# **Gatwick Northern Runway TR020005**

## **PRINCIPAL AREAS OF DISAGREEMENT SUMMARY STATEMENT – DEADLINE 5 UPDATE**

June 2024

**GATWICK NORTHERN RUNWAY PROJECT – PRINCIPAL AREAS OF DISAGREEMENT SUMMARY STATEMENT – DEADLINE 5 UPDATE**

pwl:\arup-uk-pw-bentley.com-arup-uk-pw-03\Documents\2791915-00 - GATWICK NRP SURFACE ACCESS\02 Arup\B - General Arrangements\41700-XX-B-LLO-GA-200167

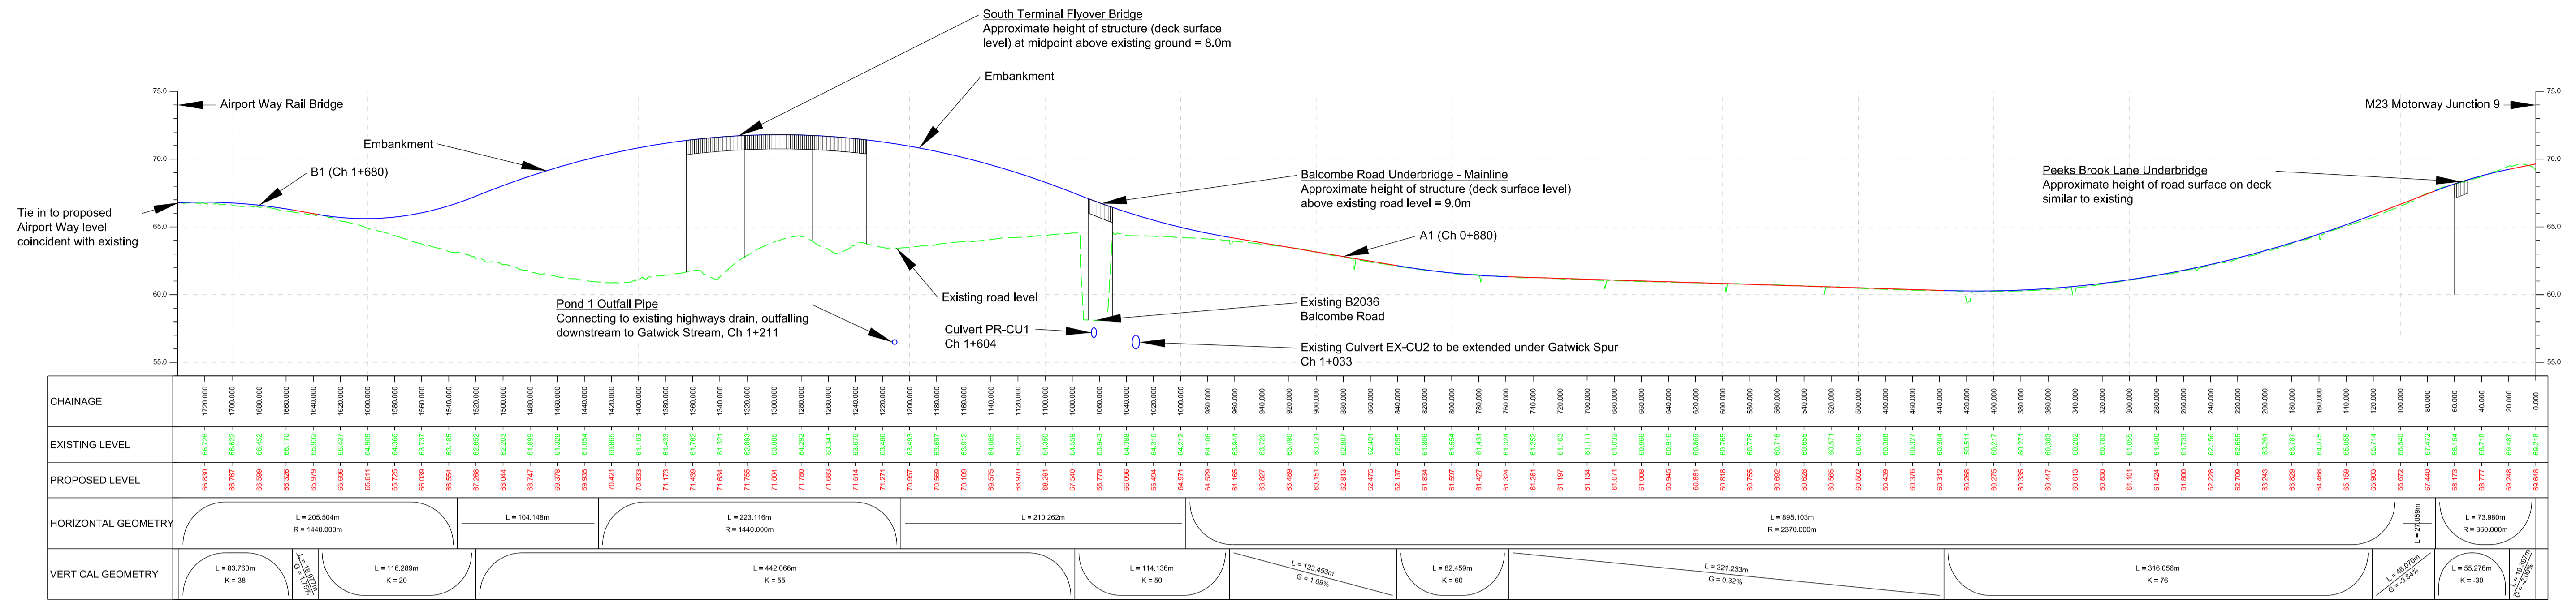
38 2.20.5.8	Structure Section Drawings (TR020005/APP/022) General	All engineering sections do not outline that headroom requirements have been met in accordance with DMRB CD127.	<p>National Highways requests that the Applicant incorporate labels or linework which denotes the headroom envelope on the elevation detail.</p> <p><b>Updated position (Deadline 2):</b> National Highways welcomes the commitment that the assessment and reporting will be undertaken in accordance with DMRB CD127. National Highways request clarity on where this is secured as part of the Protective provisions.</p> <p><b>Updated position (Deadline 5):</b> <a href="#">National Highways acknowledges the responses provided by the Applicant and considers that this matter is agreed for the purpose of the examination. National Highways will continue to work proactively with the Applicant during detailed design.</a></p>	High	<a href="#">Yes</a> <a href="#">Matter concluded at Deadline 5</a>
